PLANNING AMENDMENT

H12/1058/99

RESIDENTIAL DEVELOPMENT (4NO PLOTS)

Description: Erection of one 3, two 4 bed
detached houses, and one 4 bed
detached bungalow all with
double garages

CLYDE-2

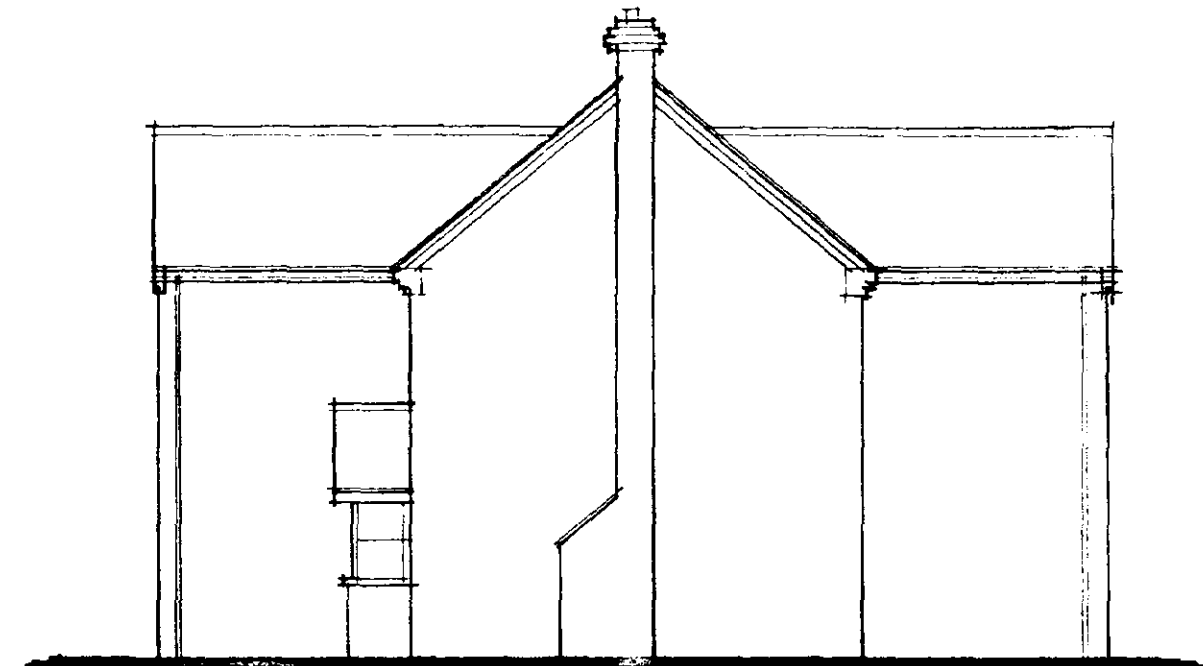
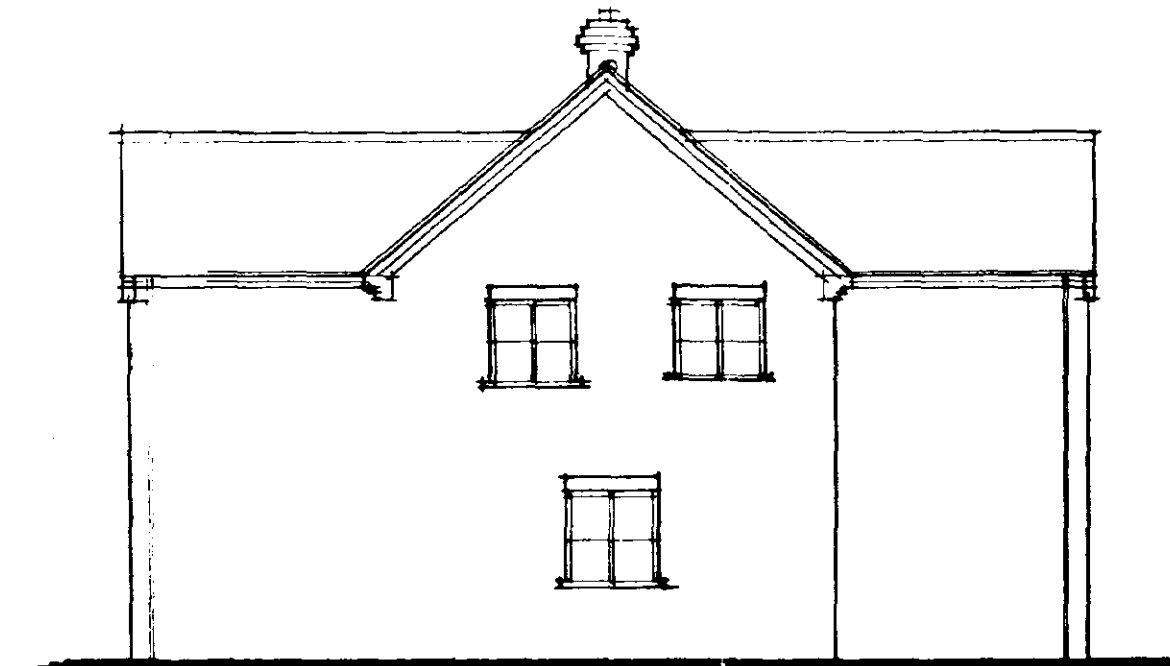
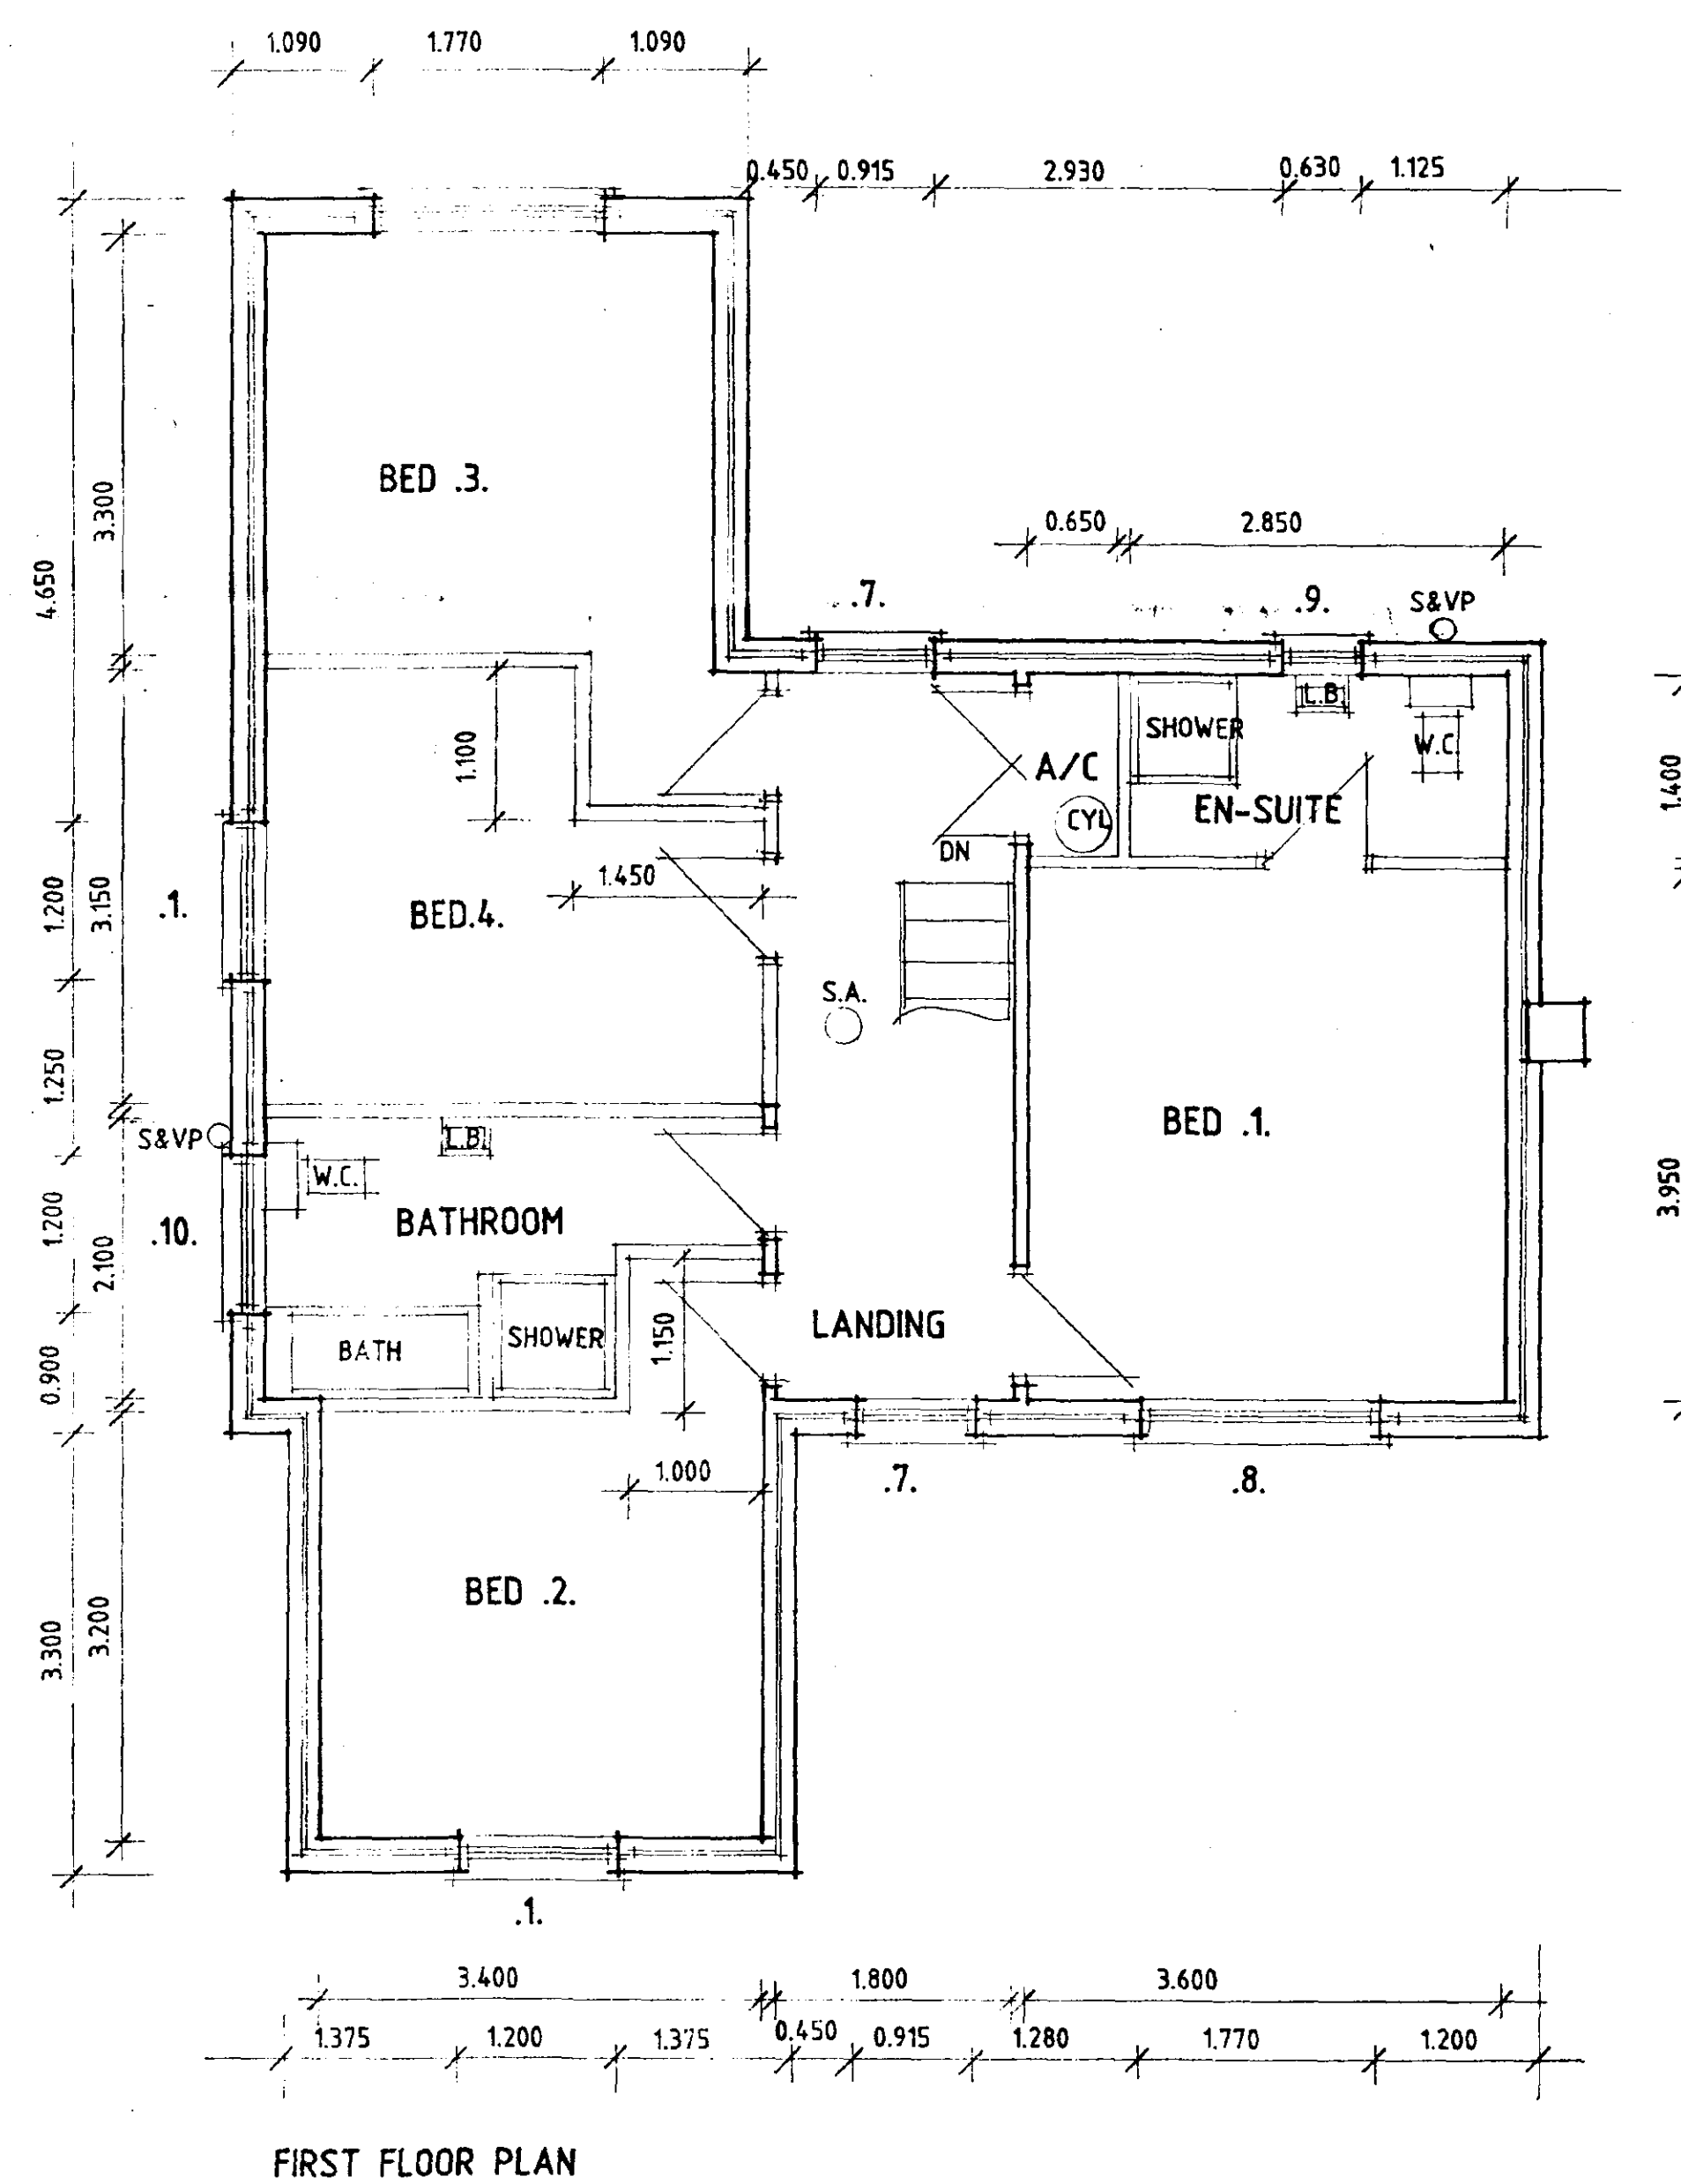
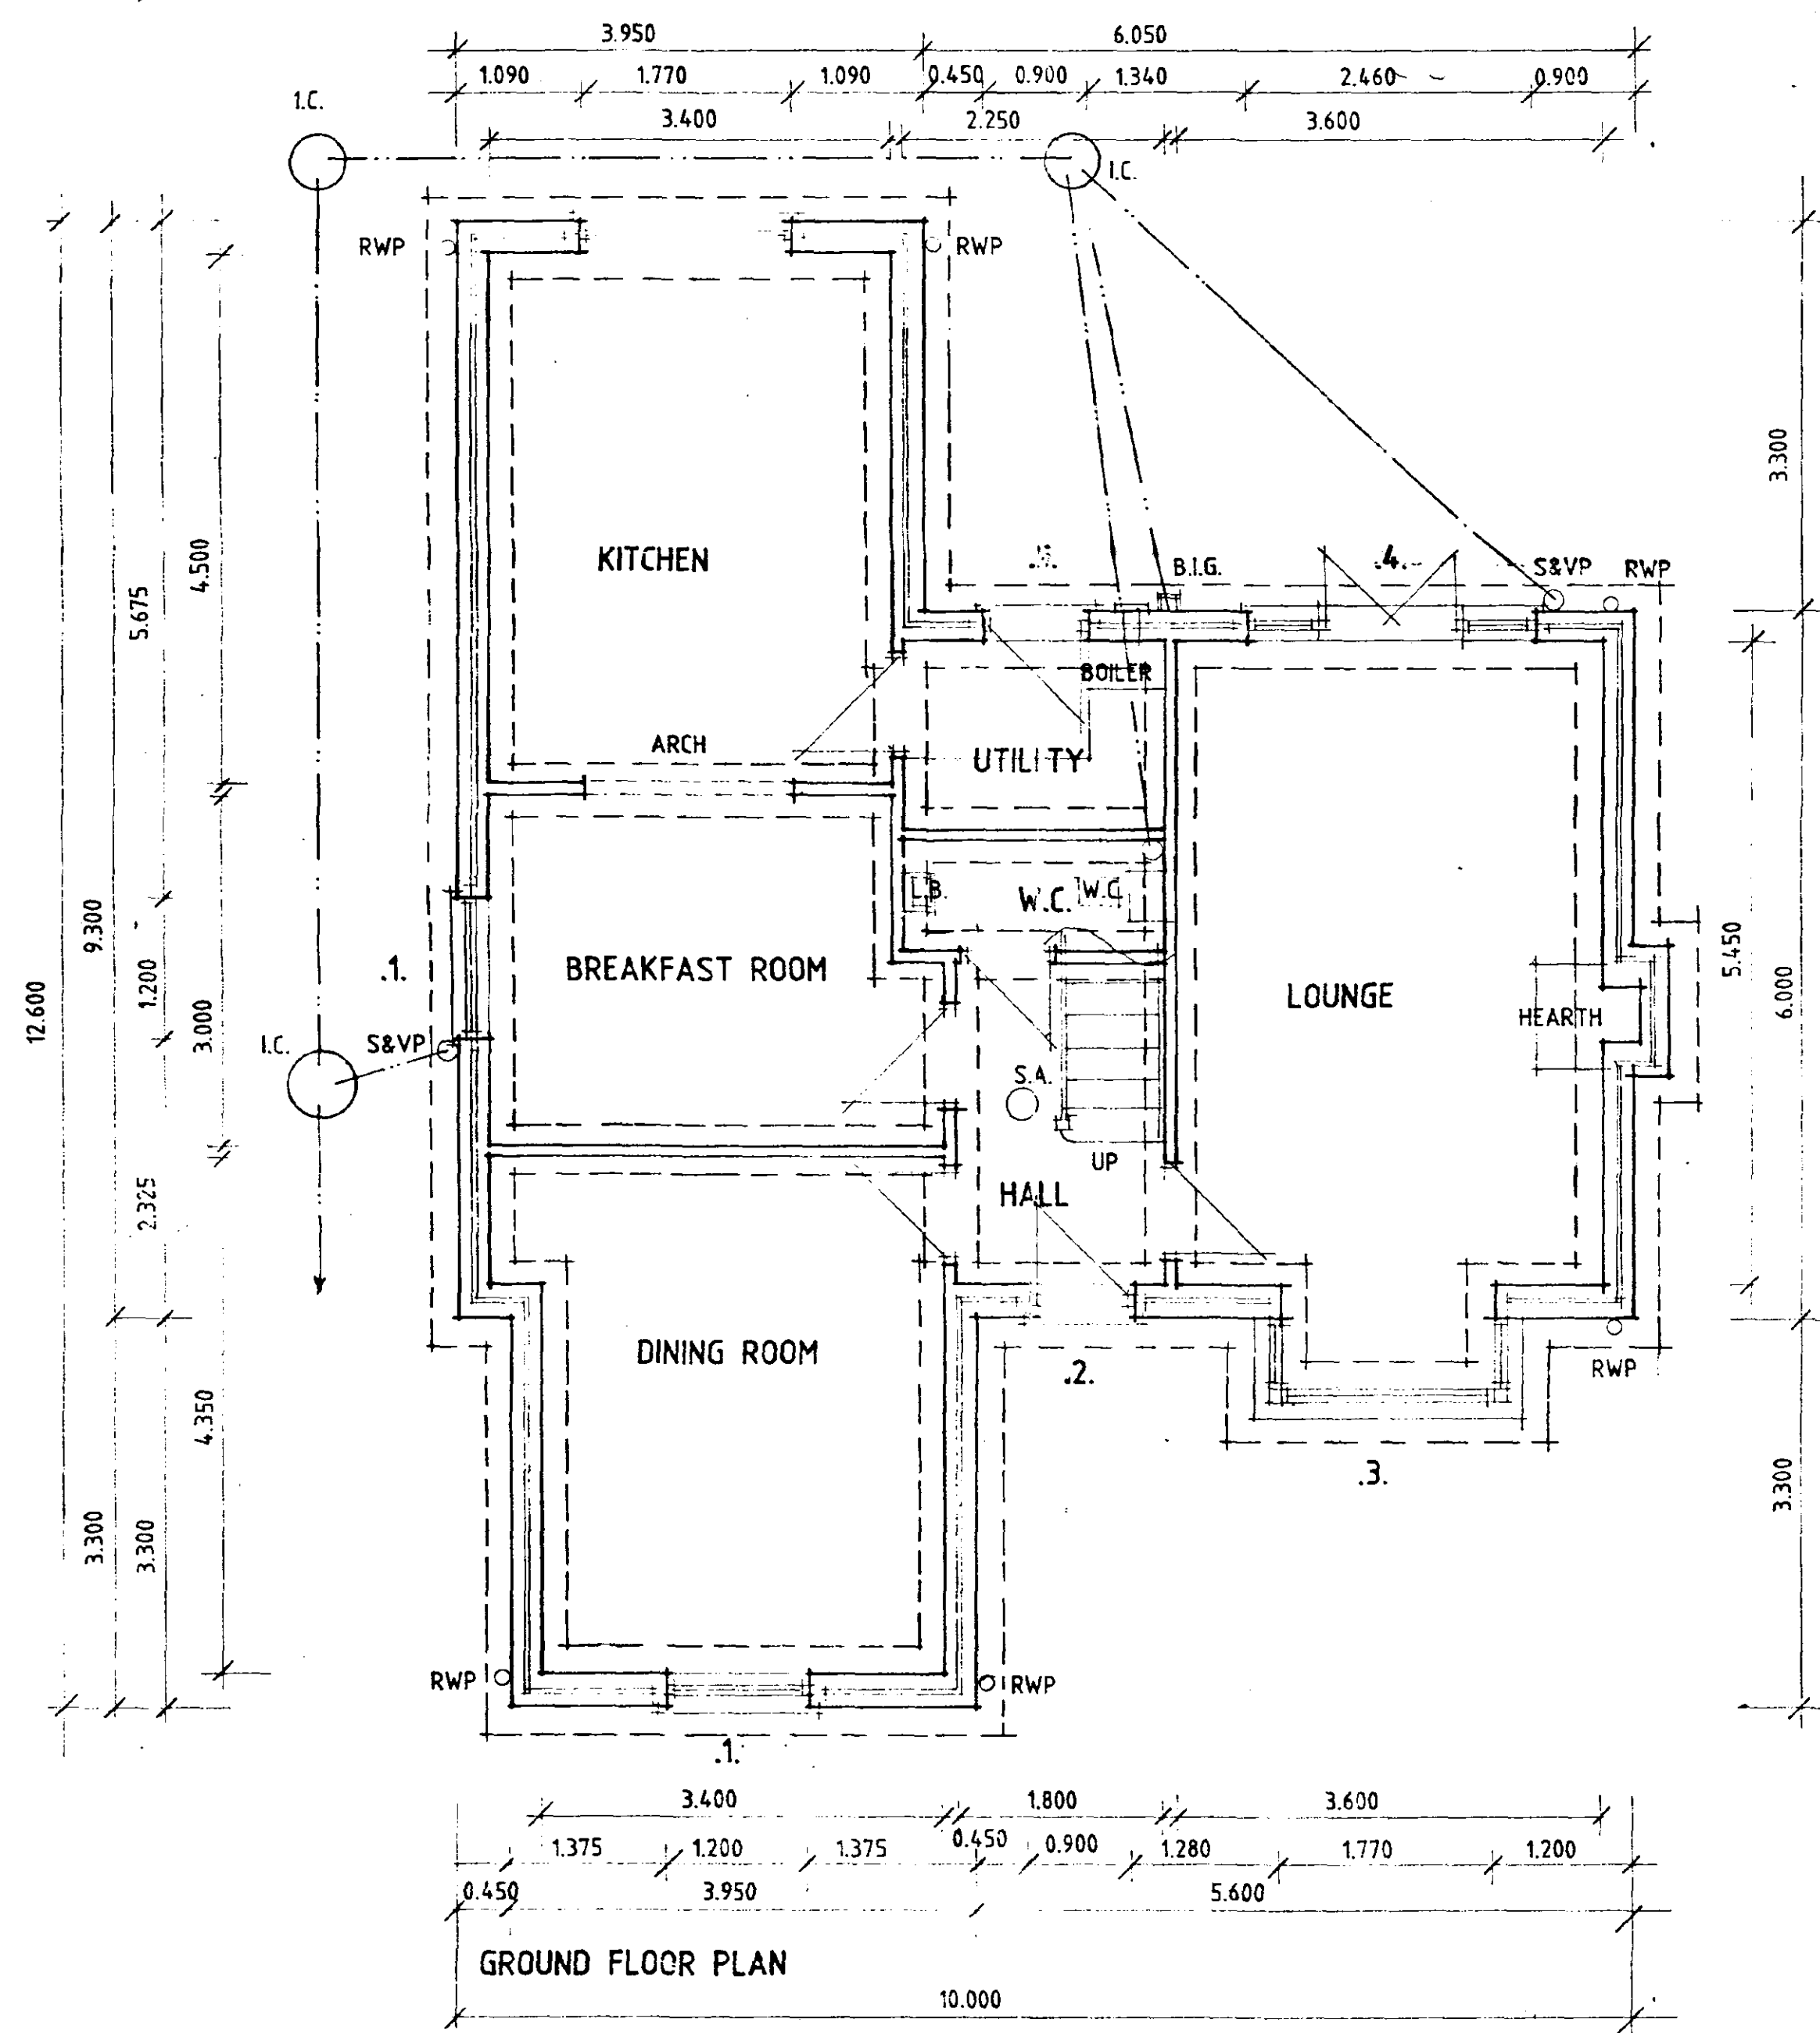
Amendment: Change bay window to standard window
Add tiled canopy over front door

**1. DELETE BAY WINDOW + REPLACE WITH
STANDARD.
2. TILED CANOPY OVER FRONT DOOR**
